**200 Aldington Road Industrial Estate (SSD-10479)
Request for additional information**

I refer to the supplementary Response to Submissions (RTS) report submitted for the 200 Aldington Road Industrial Estate (SSD-10479).

Attachment 1

TYPICAL SECTION - ESTATE ROAD 01

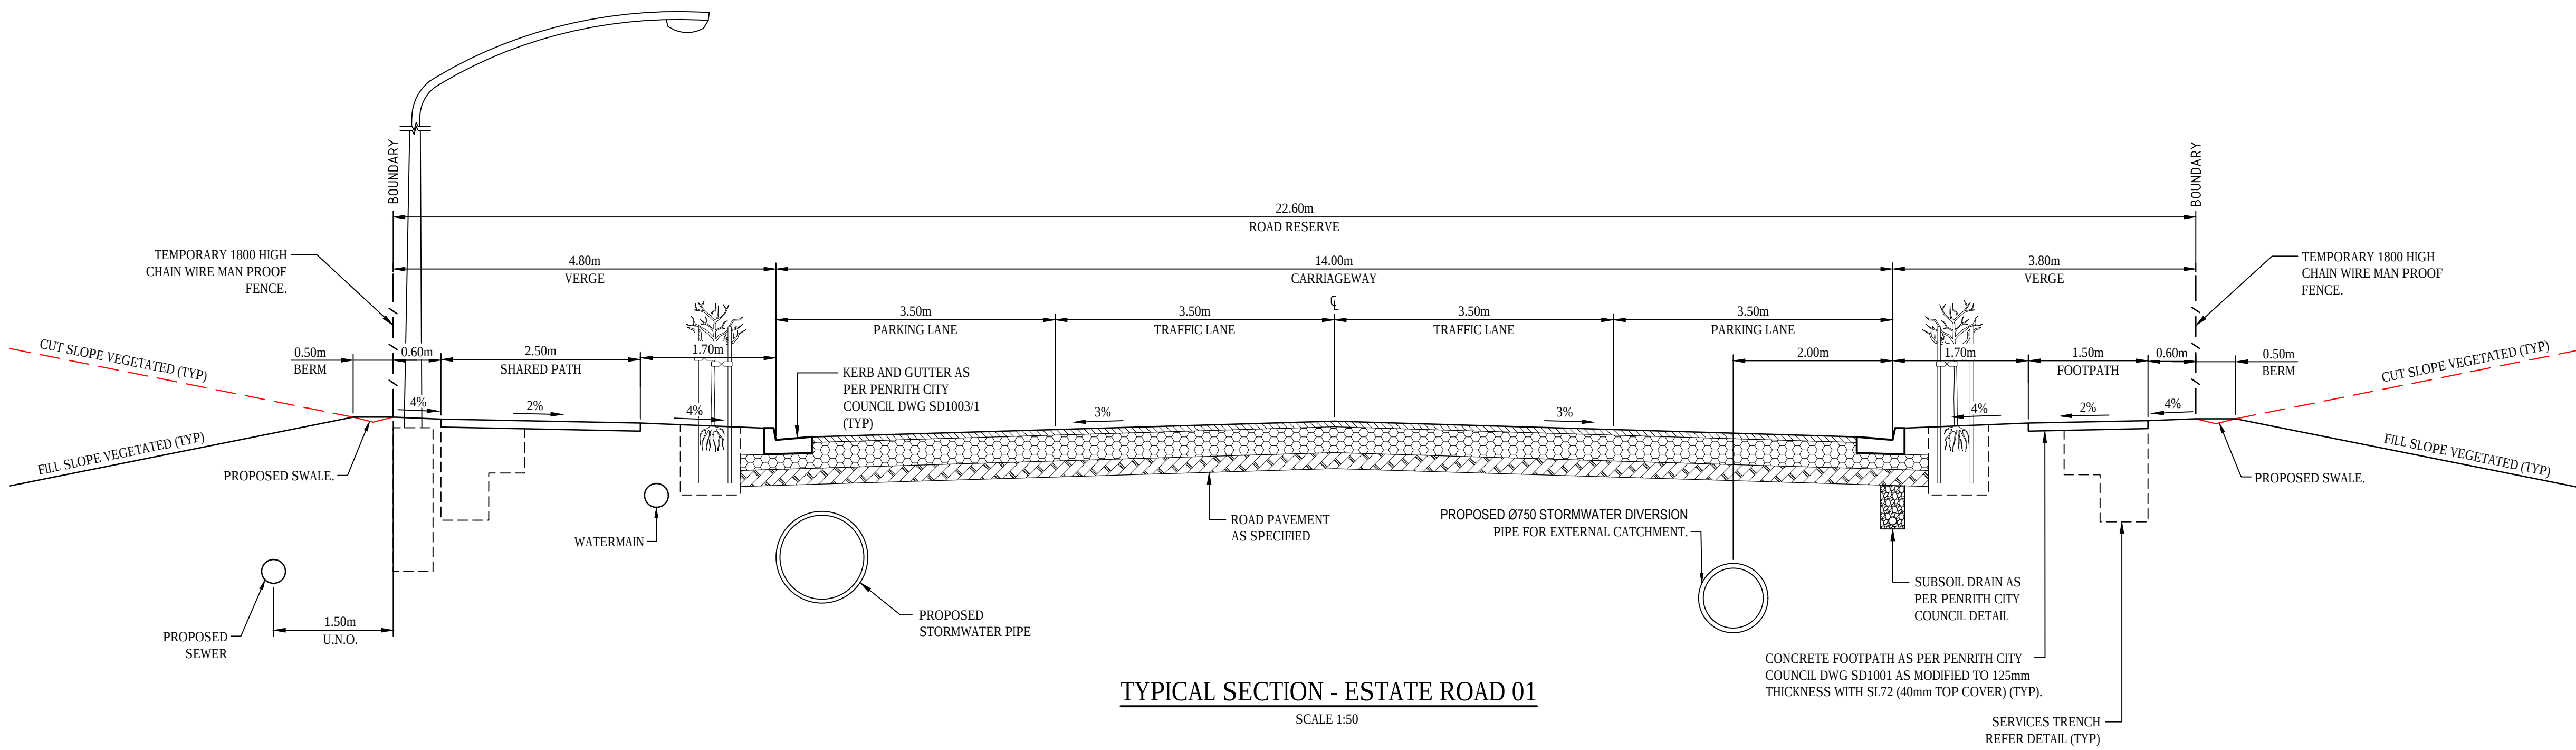
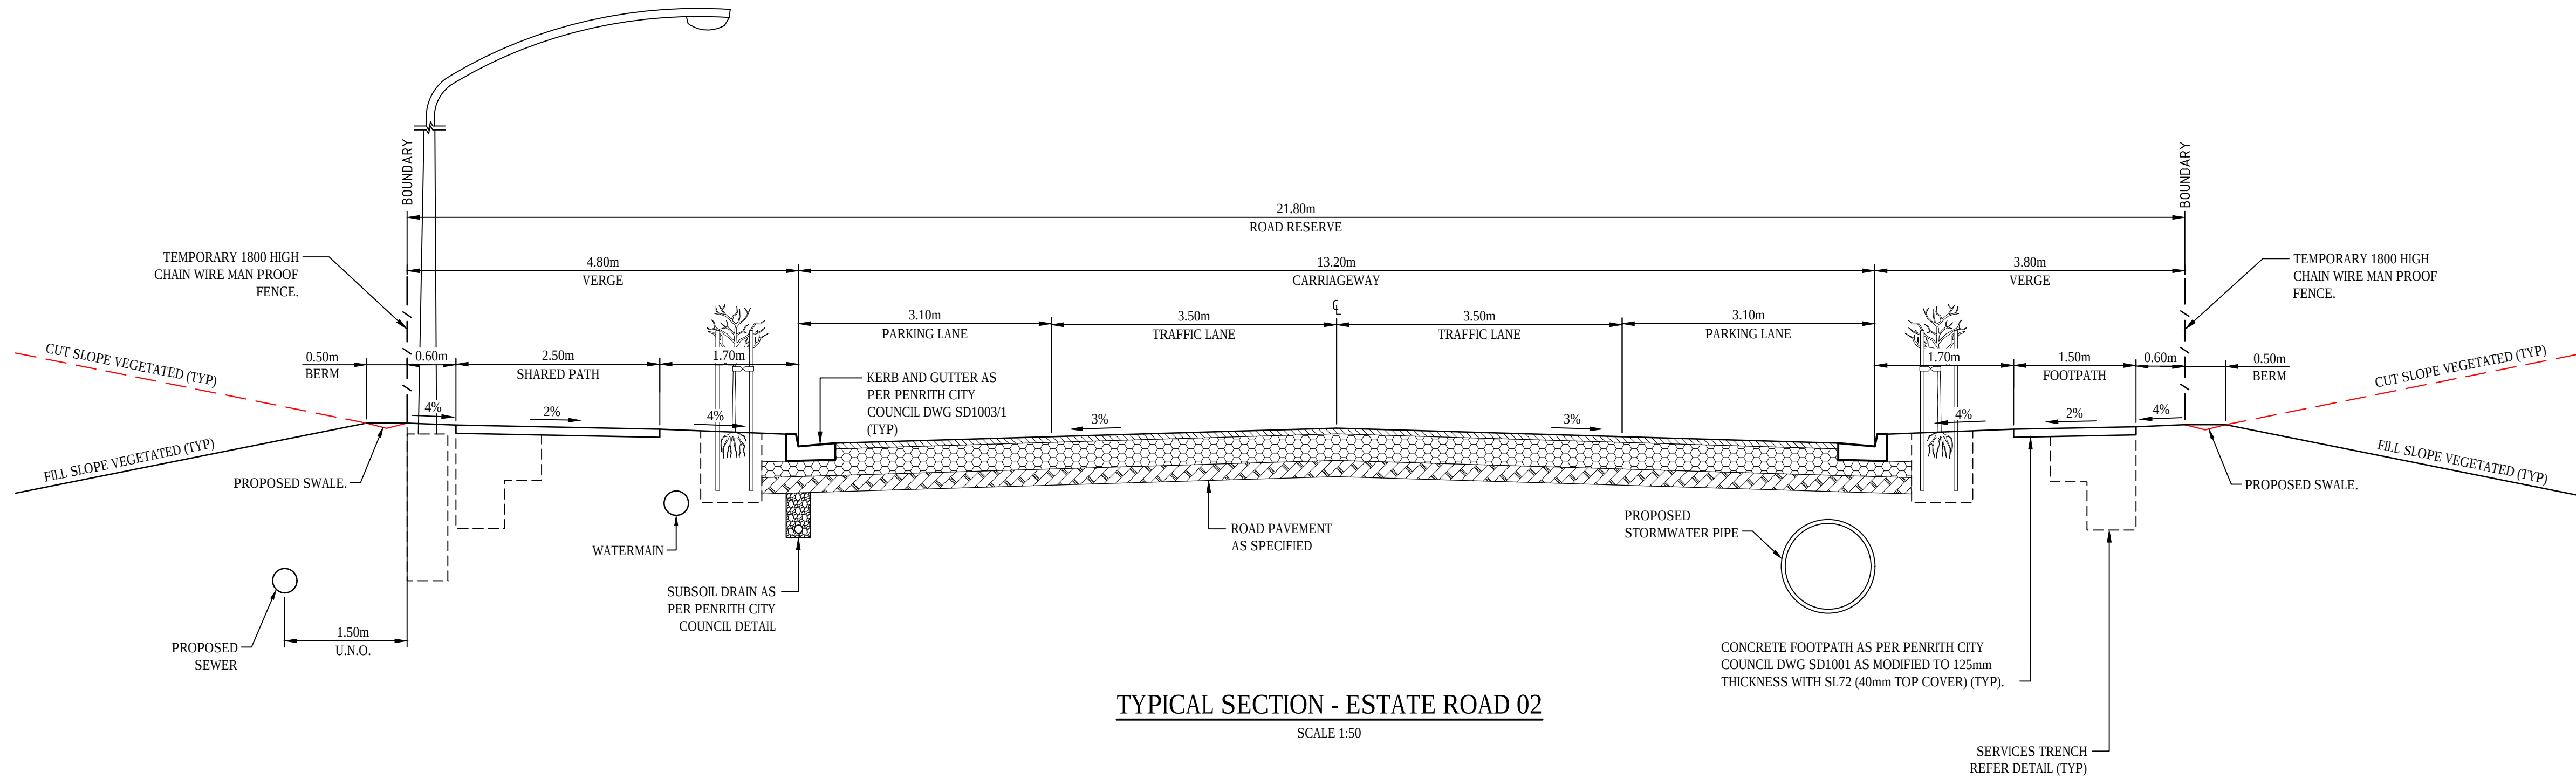
- Provide evidence of consultation with landowner directly to the east with regard to the proposed road connections to their site (as mentioned in Section 7.2 of the RTS report).
- The Department notes that the proposed roads have been designed with widths based on the 'expected' final MRP DCP. Unless the DCP is finalised in the meantime, the development should be designed to be compliant with the draft MRP DCP.

**BOUNDARY
INTERFACE
PLAN**

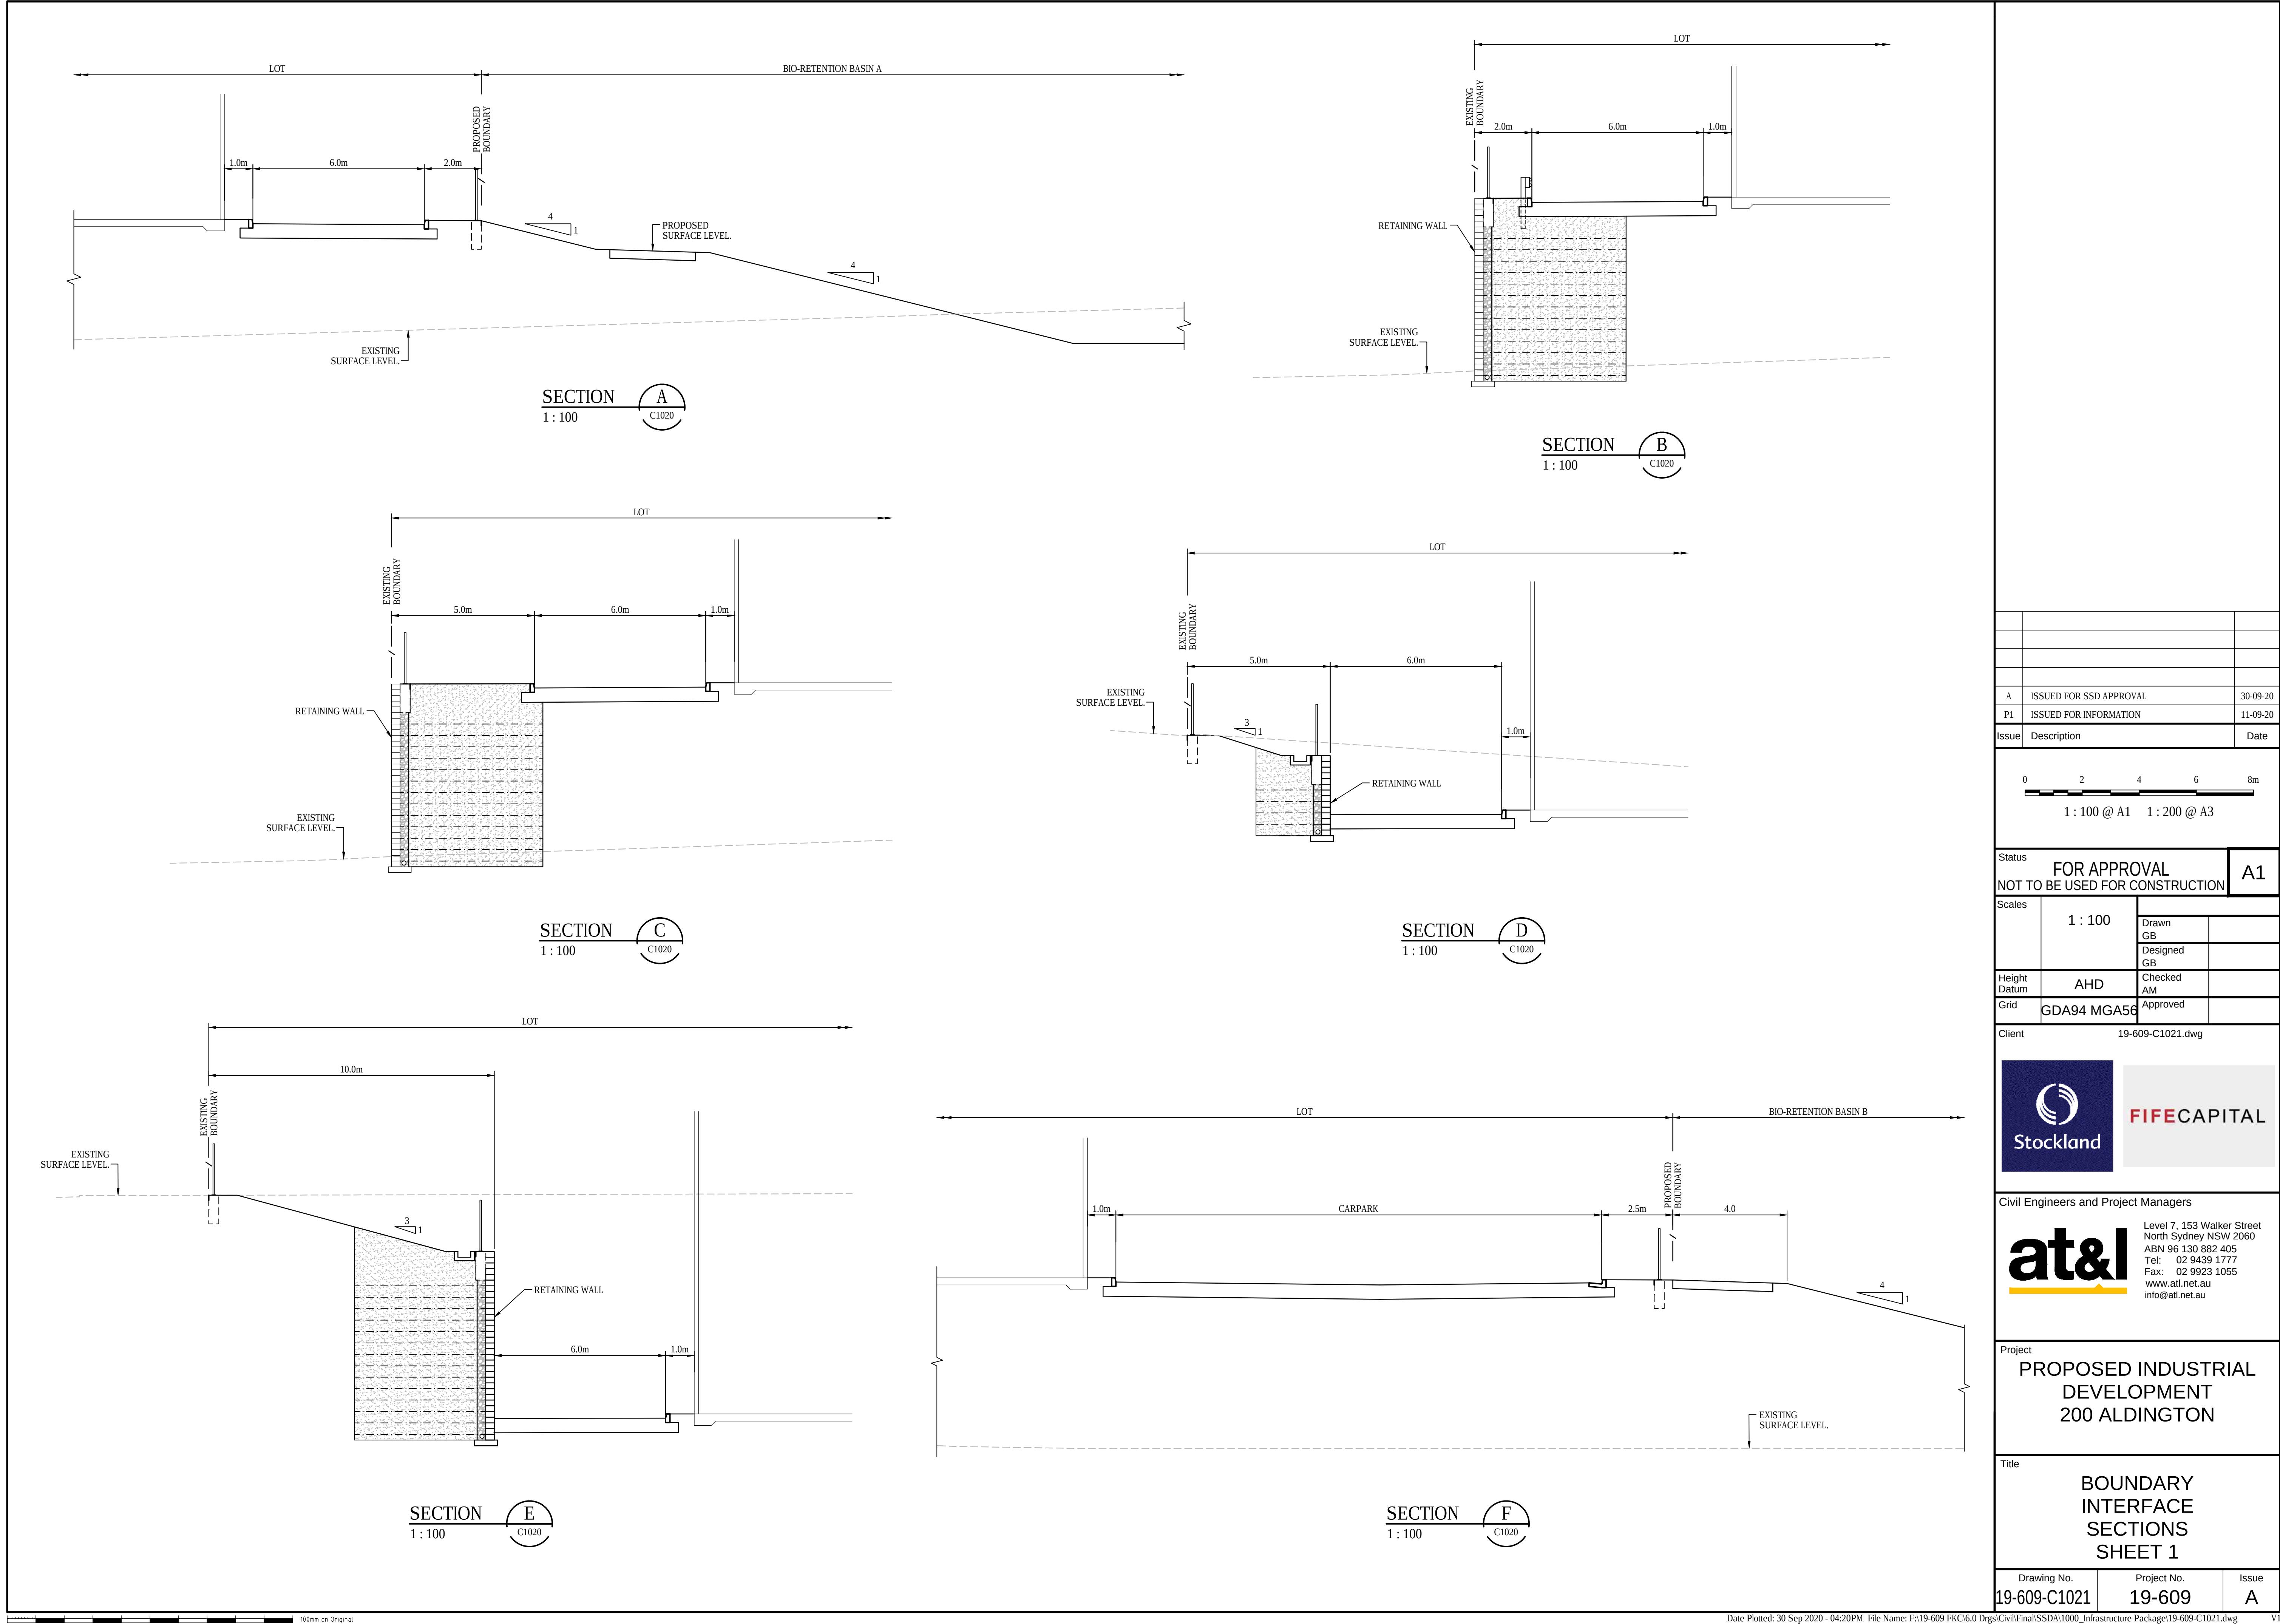
- The Department continues to have concerns with the proposed fill retaining walls along the southern boundary of the site, including the height, design and adequacy of landscaping treatment to reduce visual and bulk impacts to the adjoining property. The draft MRP DCP requires retaining walls over 3.0m high be tiered.

- Please clarify how landscaping between the proposed retaining walls and the external property boundaries will be accessed and maintained.
